**Wylfa Newydd Development Consent Order
Landscape and Habitat Management Strategy
Commentary on ecology and land management by National Trust**

1. This evidence relates to Document 8.16 (APP-424 & APP-425) Landscape and Habitat Management Strategy (Parts 1 and 2), contained within Volume 8: Other Documents (Part 9/19). The status of this document is set out in the Draft DCO Explanatory Memorandum, Document 3.3, (APP-031) page 63, paragraph 10.9.2 (e):

Figure 6-18 Proposed land use

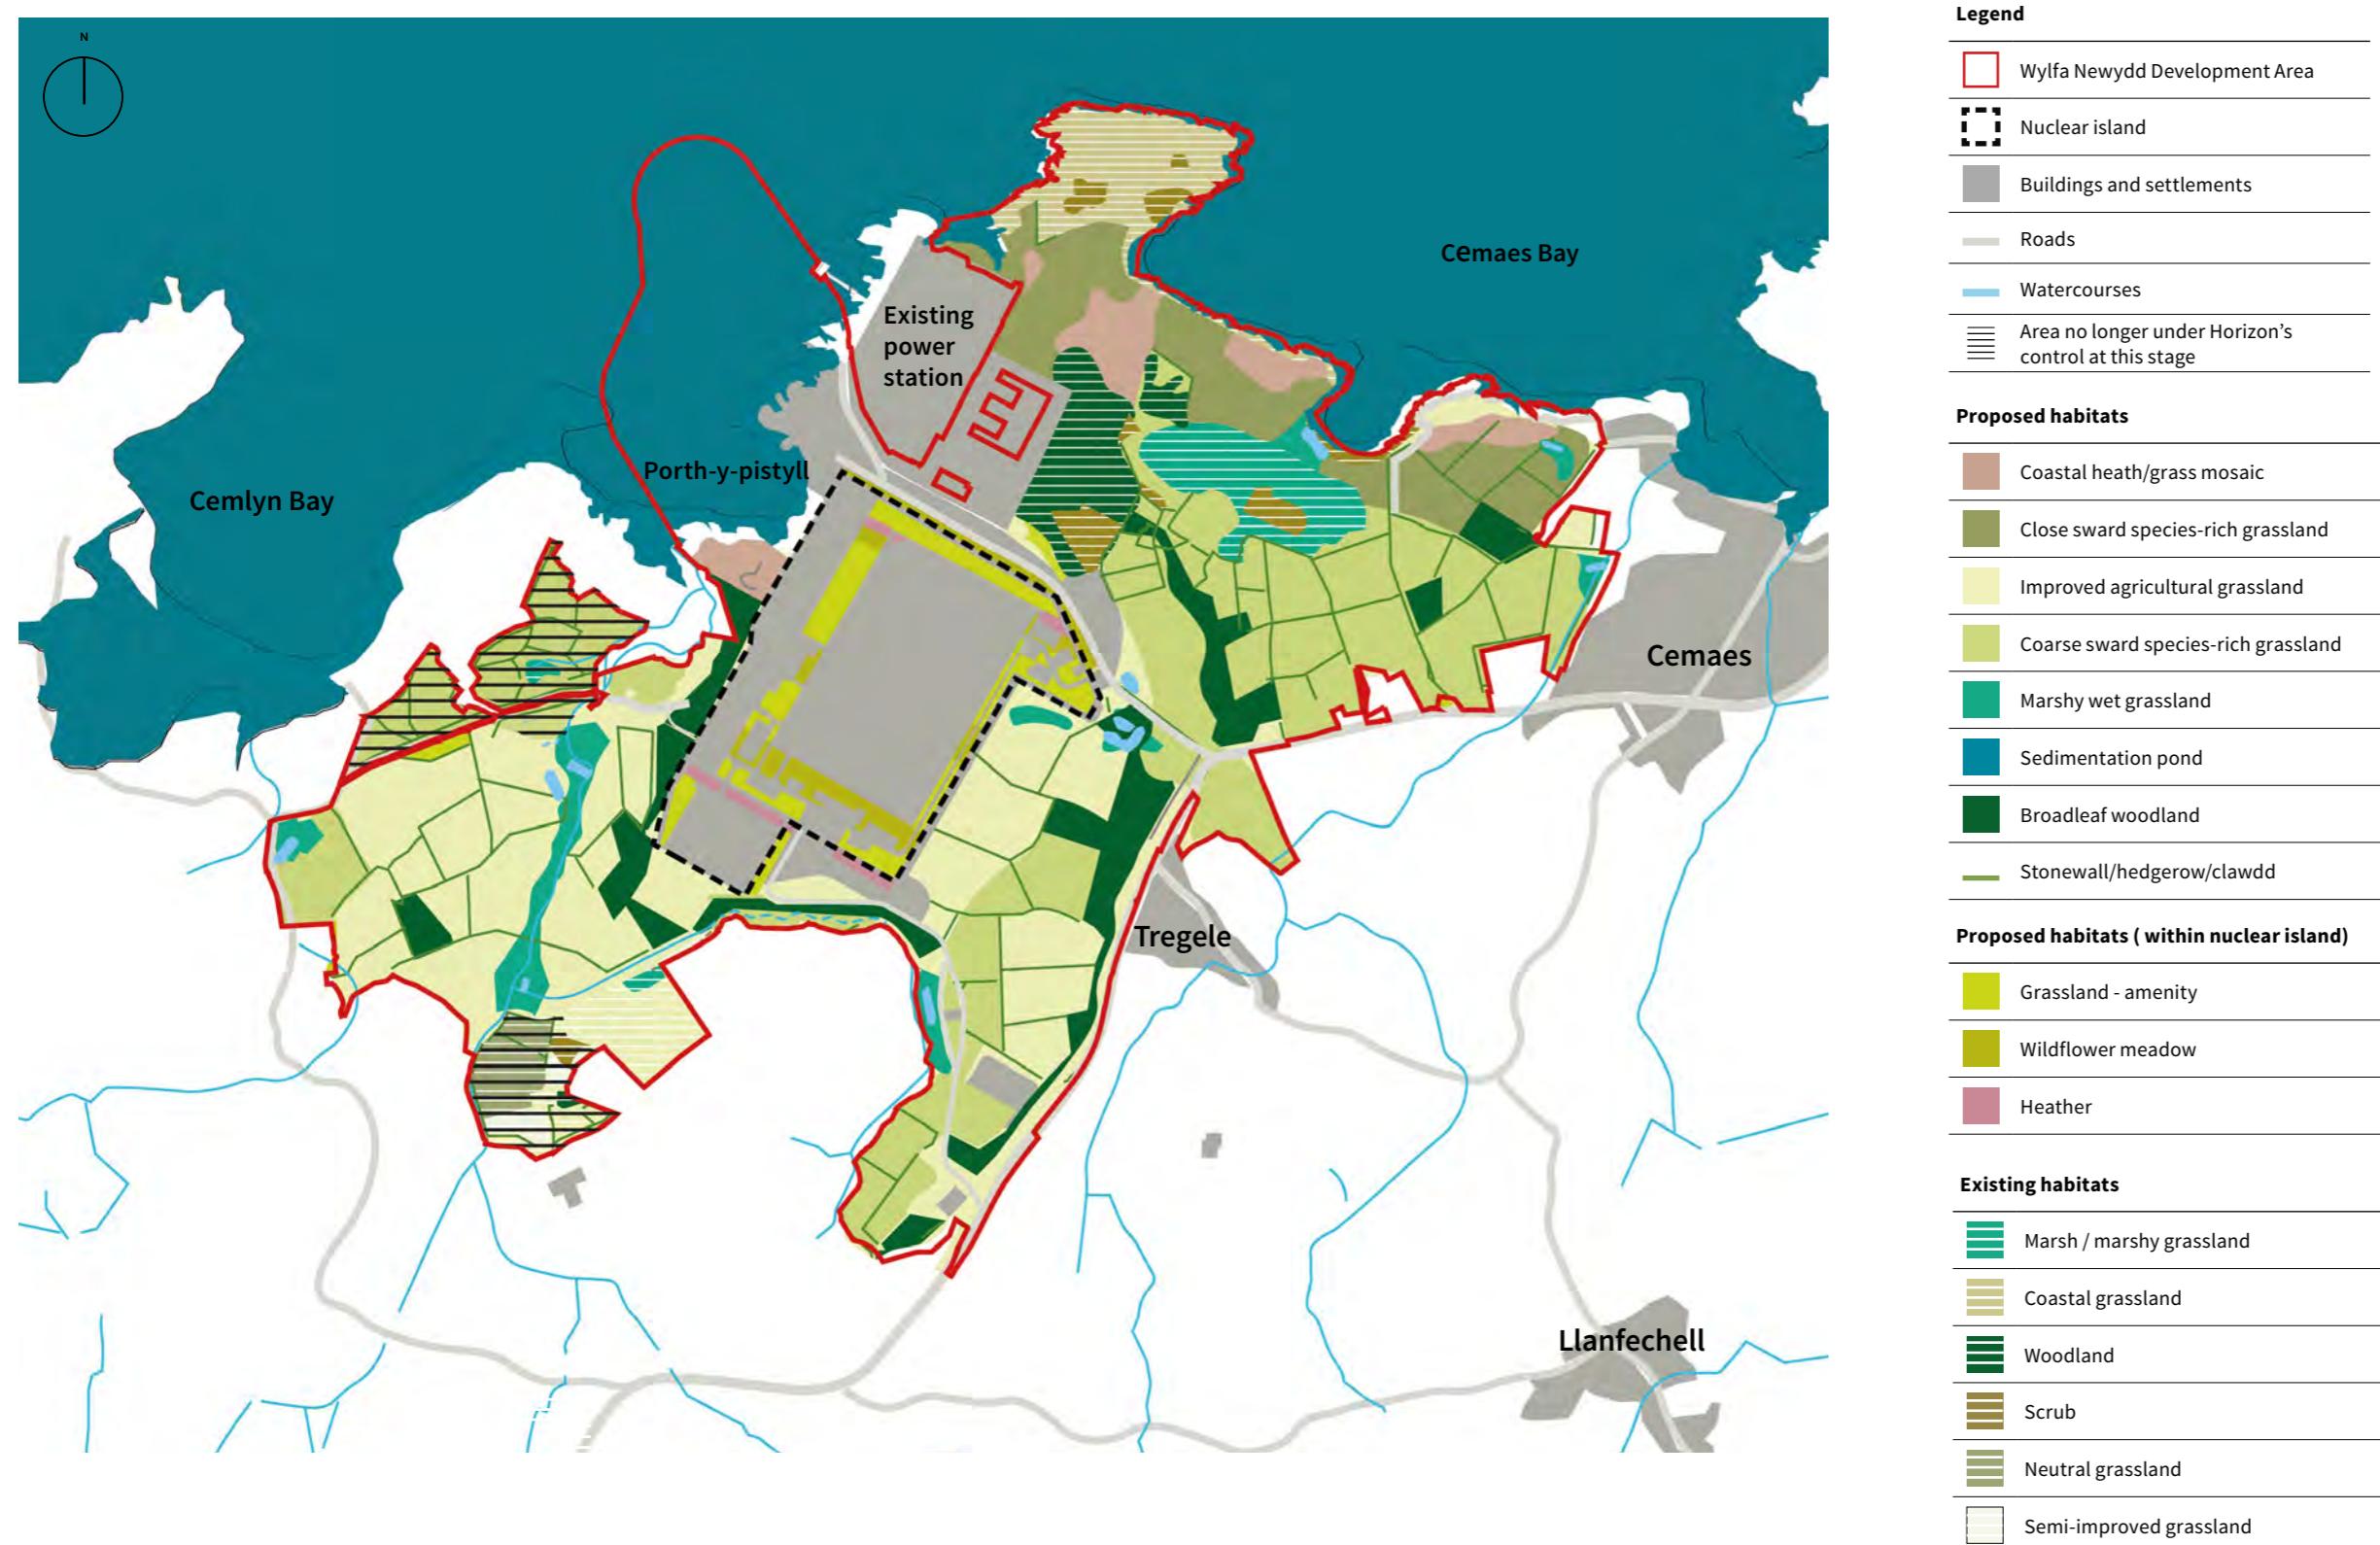
Our major concern is the 100ha of “species-rich grassland – coarse sward”, which is twice the area of other proposed grasslands and fen (not including the 40ha of “sympathetically managed agricultural grassland” discussed in the following paragraph). A coarse sward grassland normally develops when a species-rich grassland transitions to a poorer quality habitat, usually due to lack of appropriate management. The description in the LHMS, paragraph 6.5.8, suggests the habitat will comprise primarily species of MG5 grassland, but these species do not produce a

coarse sward habitat. We are concerned that attempting to create as much as 100ha of this habitat could lead to major problems and be a missed opportunity to create habitats of higher biodiversity value. Given these concerns and the greater biodiversity value of the other proposed habitats, it is recommended that their indicative areas are revised to greatly reduce the area of course sward grassland. This will allow additional areas of higher quality habitat to be created.

7. Given the overarching ecological aims of the terrestrial habitat creation and management proposals for the WNDA, nature conservation (within the overarching landscape design parameters) should be the primary objective for the whole site. It follows that the 40 ha of “sympathetically managed agricultural grassland” is not needed within the WNDA and more habitat can therefore be created. We now understand, from a recent meeting with Horizon Nuclear Power (HNP), that this proposal has been withdrawn and 40 ha of new additional habitats will be created instead. We welcome this change to the LHMS as long as additional high quality habitats are proposed. Whereas many habitats will require grazing management to maintain the correct ecological conditions for target species, agricultural objectives should be secondary to ecological ones in order to maximise biodiversity value.
